Our Ref: BR/199/19/PL

**Town & Country Planning Act 1990 (as amended)
Town and Country Planning (Development Management Procedure) (England) Order 2015
Application for Planning Permission**

Development Conversion of existing Health Centre (D1 non-residential institution) unit to 4 No. studio flats. This application may affect the setting of a listed building.

Location Clock Walk 7 High Street Bognor Regis

02 Site Block Plan
Scale:1:500

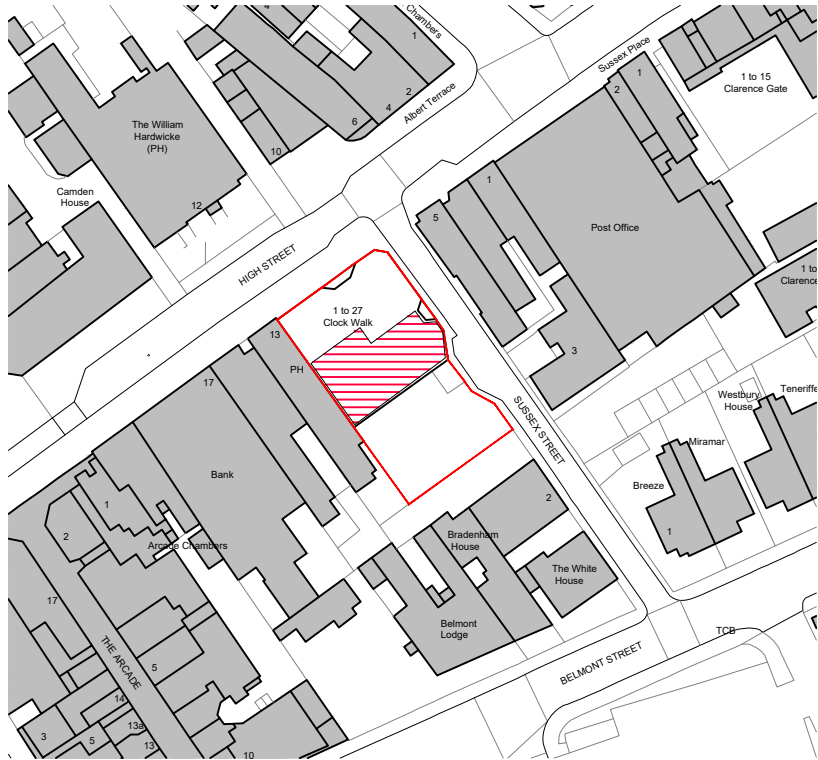
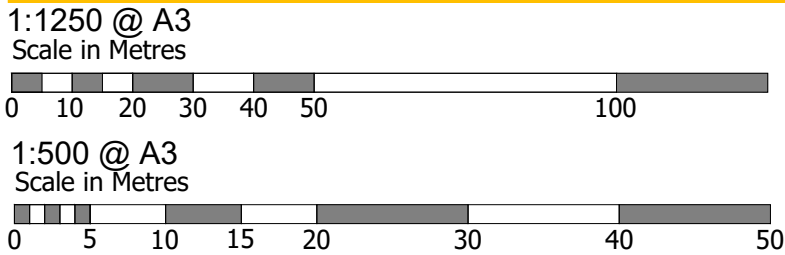
Block Plan Amend

Please clearly highlight/hatch only the proposal.
